Your Ref: OWPC13952
Our Ref: FG/198/16/PL
Please ask for:
Mr A Wood

11th May 2017

Demolition of existing house with erection of 2 storey building comprising of 8No.
residential 2 bedroom flats & associated external works
1 Sea Drive Ferring

PROJECT: 1 SEA DRIVE
HARRISON WORTHING
BRIEF 5/10
TITLE: PROPOSED ELEVATIONS
AND STREET SCENES

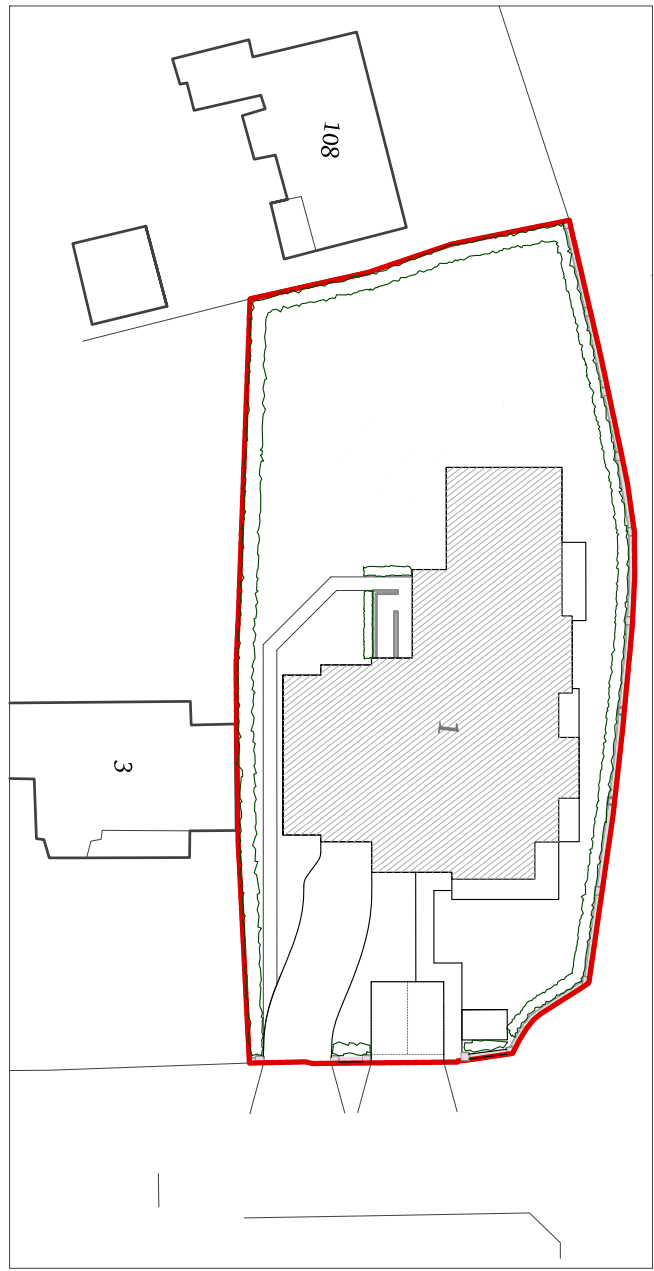
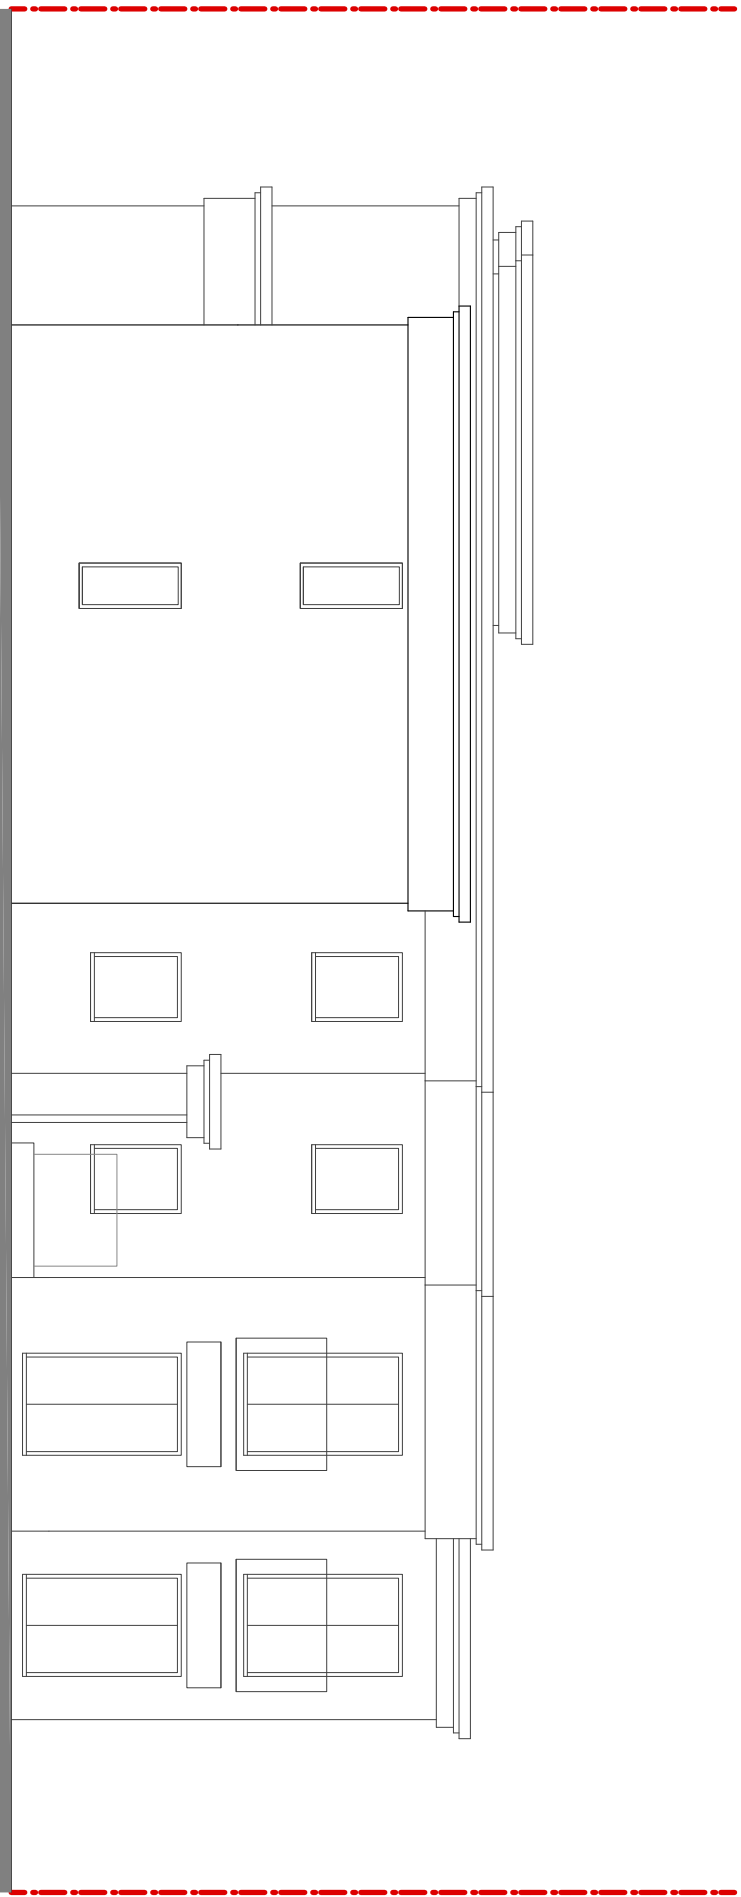
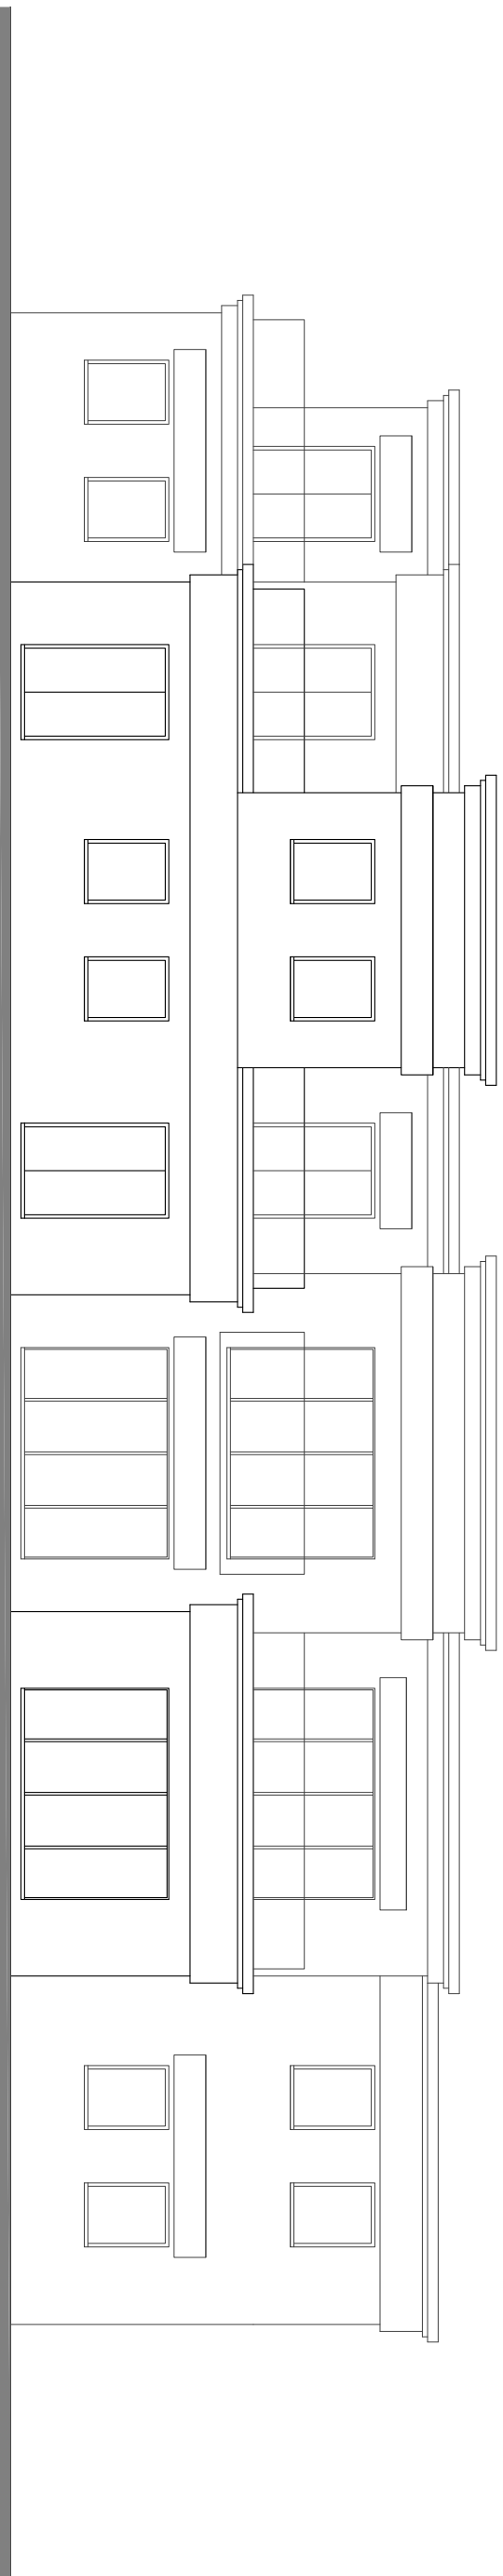
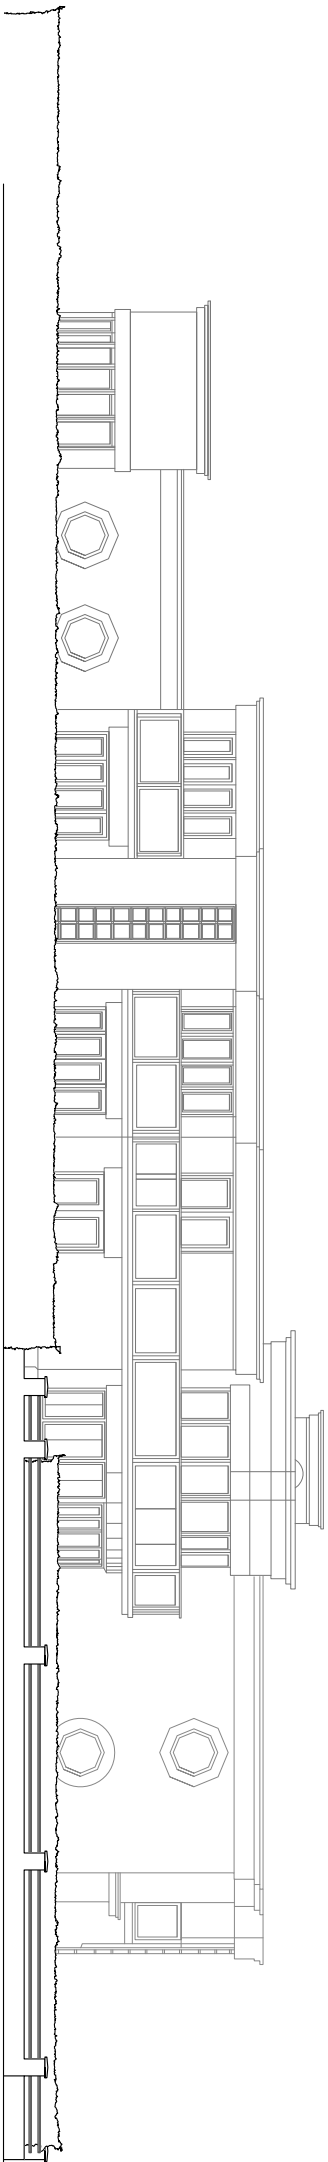
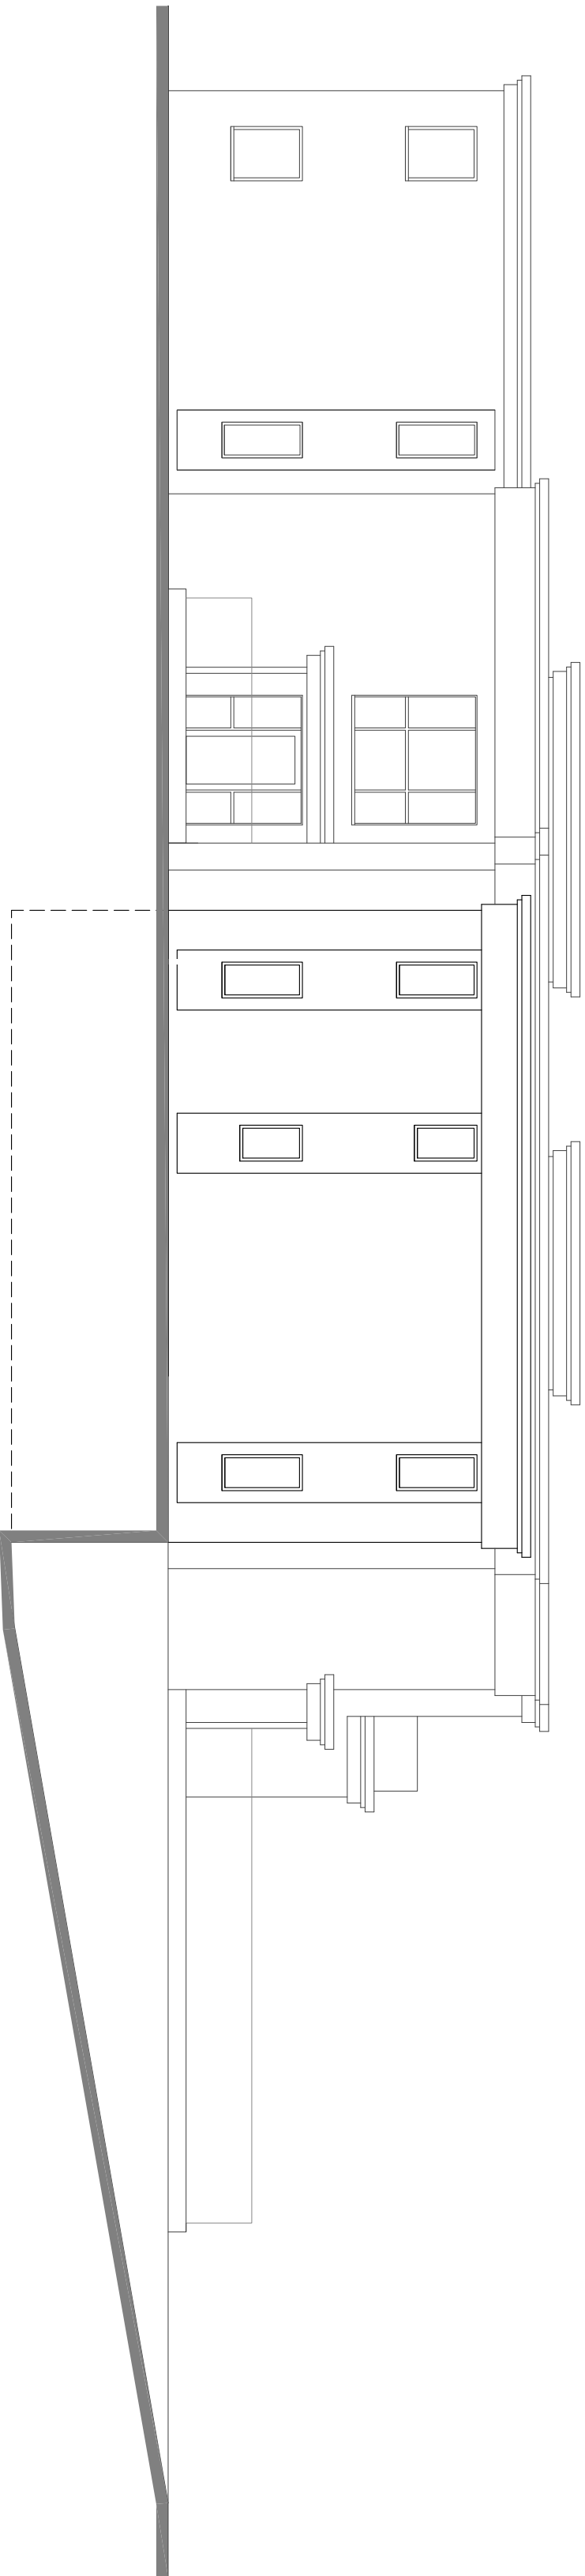
*Although not illustrated in the plans, due to the addition of the underground car park, this
will inevitably raise the height of the proposed development. The development is
substantial and, by virtue of the design, form and height scale, the proposed will impose
and will be domineering and overbearing on the neighbouring properties.*
